March 15, 2024

Property Owners: Sugar Daddys, LLC
SSRW Residential Partners LP Ltd
SRW Residential Partners LP Ltd
Turkey Canon Quarry, Inc.
SR Land, LLC
Rhetoric LLC
Developer: RSC Metro, LLC

Re: Letter of Intent for the Proposed Stonebridge Metropolitan District Nos. 1-6

STONEBRIDGE METROPOLITAN DISTRICT NOS. 1-6 DISTRICT BOUNDARIES

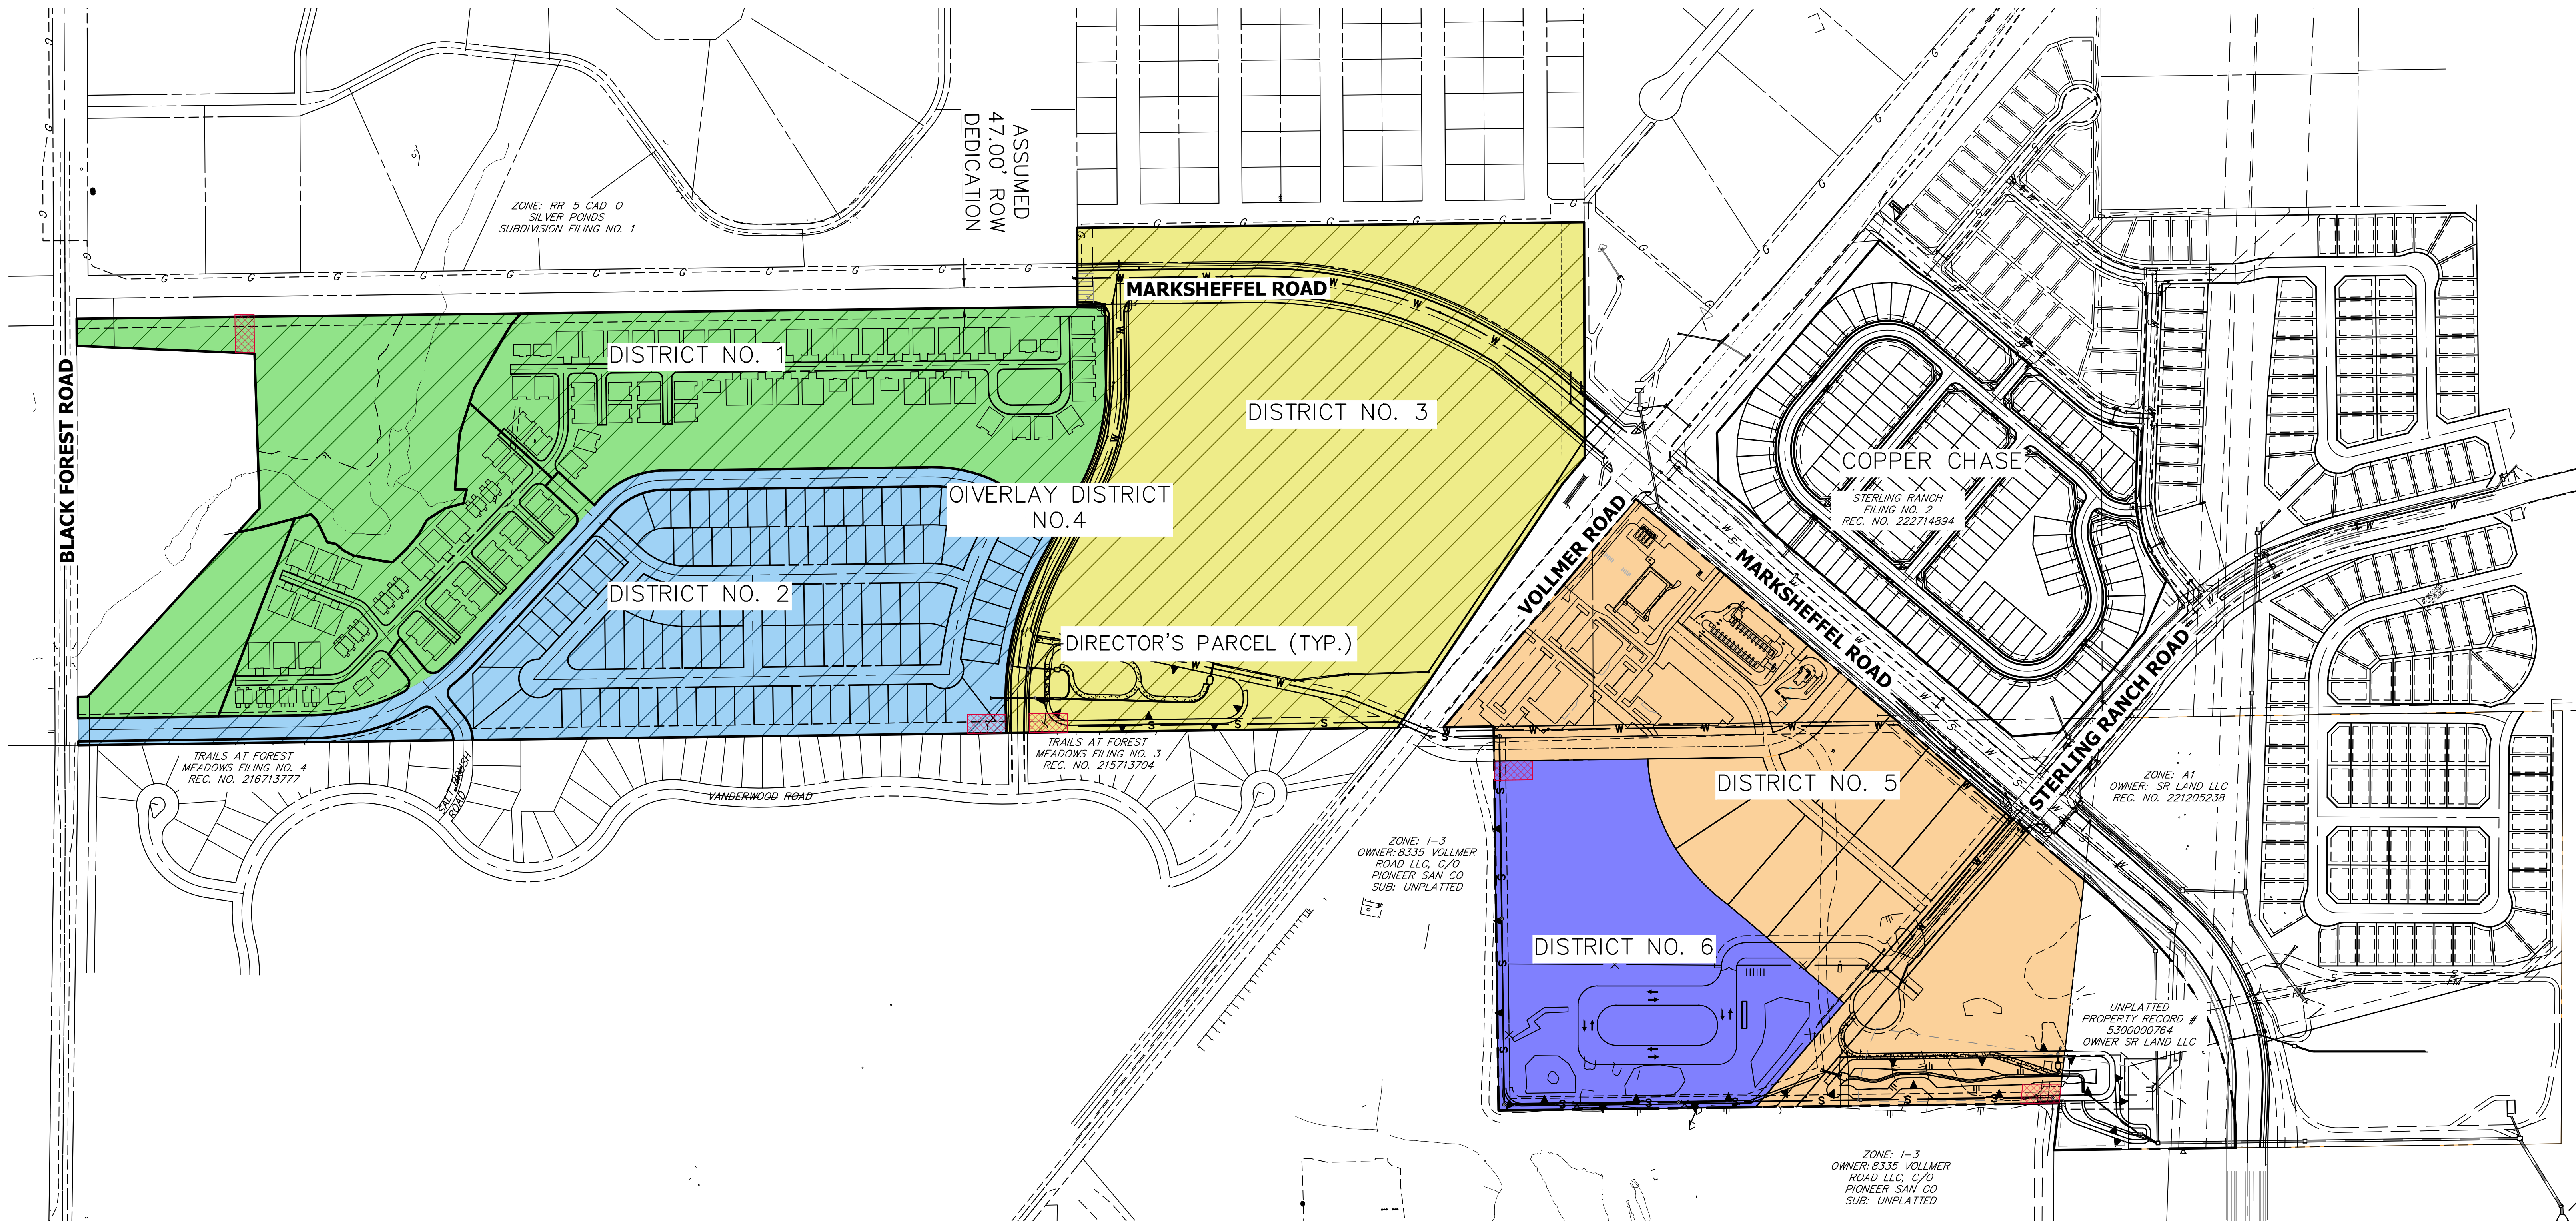
the SF seems low based on the District Boundary Map where it depicts attached single-family
